**KIRKLEES METROPOLITAN COUNCIL
INVESTMENT & REGENERATION SERVICE**

DELEGATED DECISION TO DETERMINE PLANNING APPLICATIONS

Reference No:	2024/62/92332/W
Site Address:	110, Underbank Old Road, Holmfirth, HD9 1AS
Description:	Replacement of existing rear gable window with new window (within a Conservation Area)
Recommending Officer:	Joanna Rednall

DECISION – CONDITIONAL FULL PERMISSION

| PROPOSED ELEVATIONS.               |             |        |        |           |             |

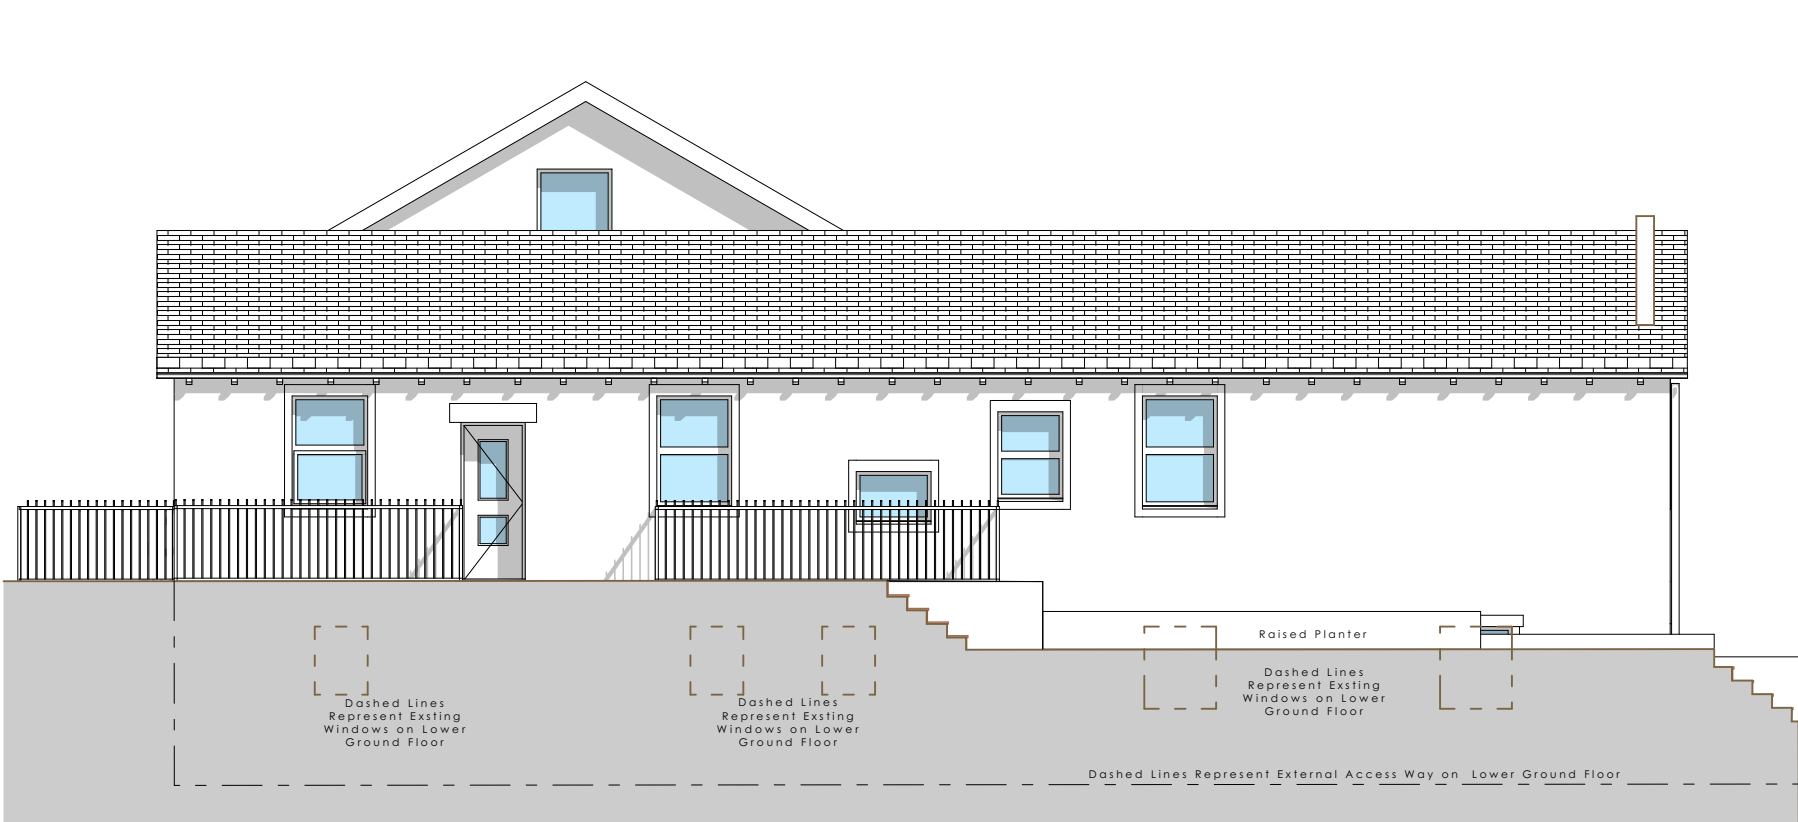
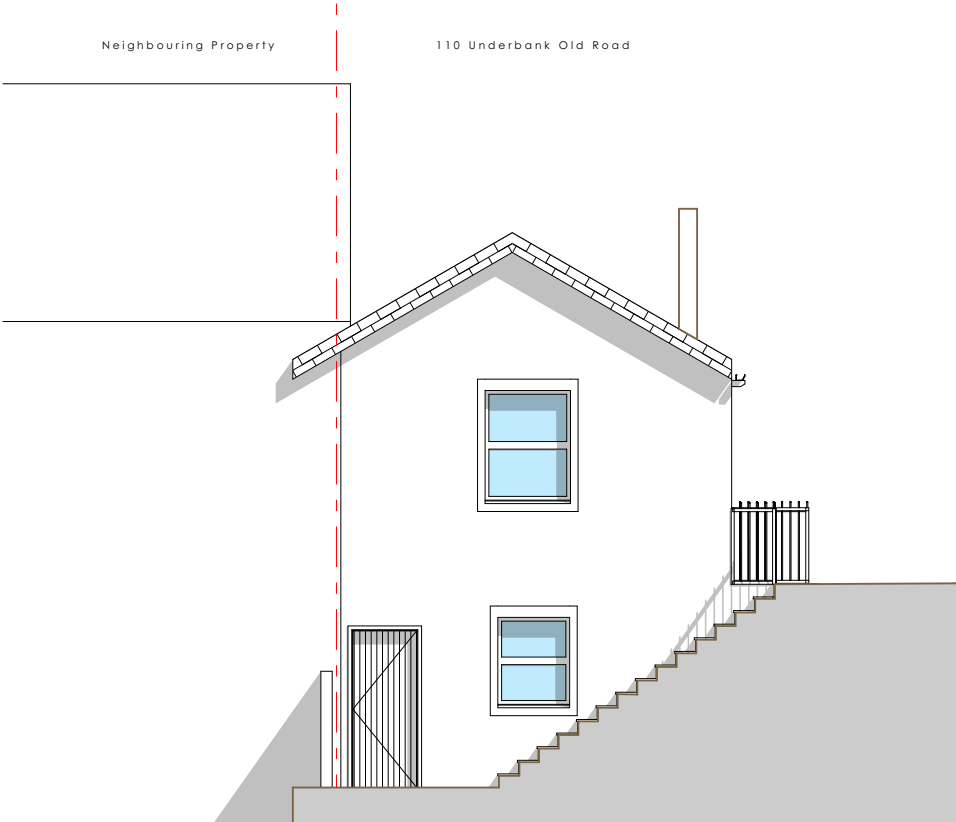
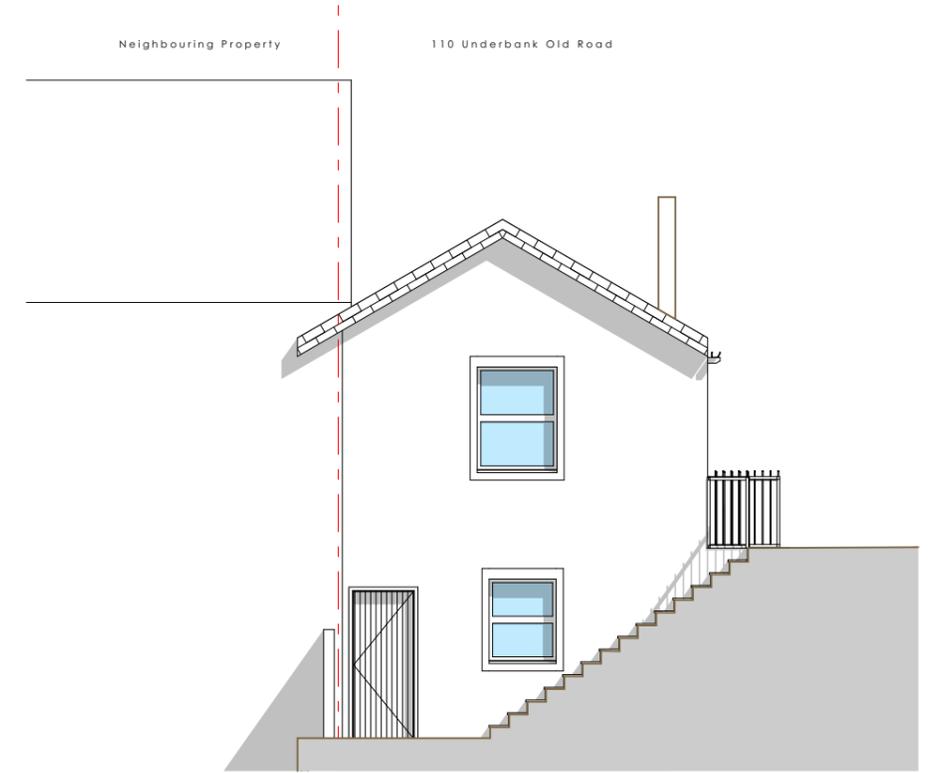
KC Conservation & Design raised concerns on the proposal's impact on the building's character and the Conservation Area. In response, revised plans were submitted on 11th November, featuring reduced glazing to address these issues.

Conservation initially objected to the proposed development on the basis the alterations would erode the character of the historic mill and would have a cumulatively harmful impact on the application site and setting of the Conservation Area. This is because although it is acknowledged that there are various different window designs within the vicinity, including similar openings at the adjoining neighbour to those proposed, the neighbouring openings appear to have been formed around historic door openings. In relation to the application property, at ground floor level there is a large curved-headed opening which officers note appears to be of some historic merit. It was therefore concluded that the submitted scheme would be unsympathetic to the character of the historic mill and the immediate character of the complex, contrary to LP35.

Following these comments, the proposal has been modified, the main changes being that the scale of glazing to the first floor has been reduced and the ground floor archway opening would be retained. This is considered to have an acceptable visual impact as the first-floor opening would appear modest in scale and constructed from matching materials to the existing window. With regards to harm to the Conservation Area, the proposed glazing has been reduced in scale with the arch opening retained in line with KC Conservation and Design's comments. The proposed alterations at 110, Underbank Old Road

3. The materials of construction of the frame of the window hereby approved shall be timber.
